CITY OF ALBUQUERQUE

**RE: Taco Cabana Cottonwood
Grading Plan
Stamp Date: 6/5/17
Hydrology File: B13D025**

TITLE: TACO CABANA @ COTTONWOOD
GRADING & DRAINAGE PLAN

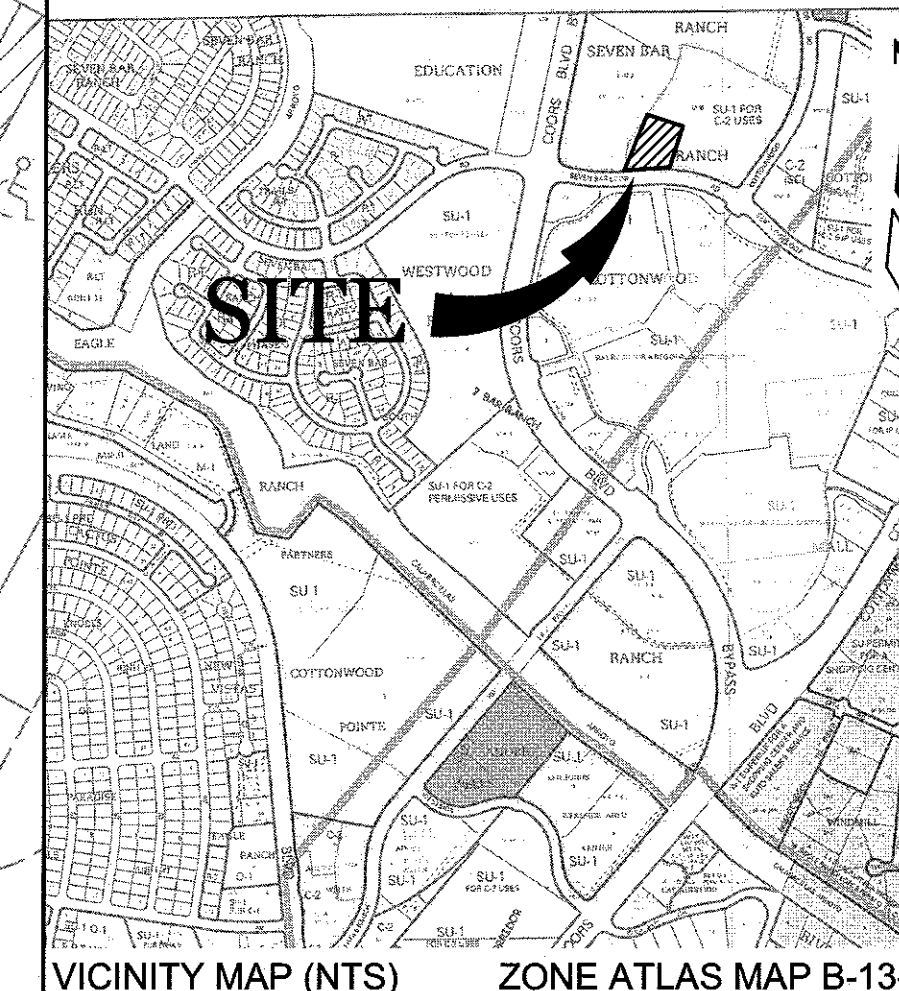
1. Please show the limits of the removal and replacement of pavement.
2. The current grading plan appears to show more than 1 acre of disturbance is being proposed. If this is the case, than an Erosion and Sediment Control Plan is required and has to be submitted to the storm water quality engineer (Curtis Cherne, PE, ccherne@cabq.gov). An approval for this must be given prior to Hydrology's approval for Grading or Building Permit.

3. Please provide first flush pond calculations. This will be within the depressed landscape areas that you have indicated.
4. Please show some curb cuts so that the runoff can drain into the first flush basins and a curb cut so that the pond can drain. Also please show the drainage going into these basins.

5. Please provide a Private Facility Drainage Covenant and Reservation of Private Drainage Easement per Chapter 17 of the DPM.
6. Please show Cross Lot Drainage Easements on both the Plat and the Grading & Drainage Plan specifying the beneficiary and maintenance agreement.
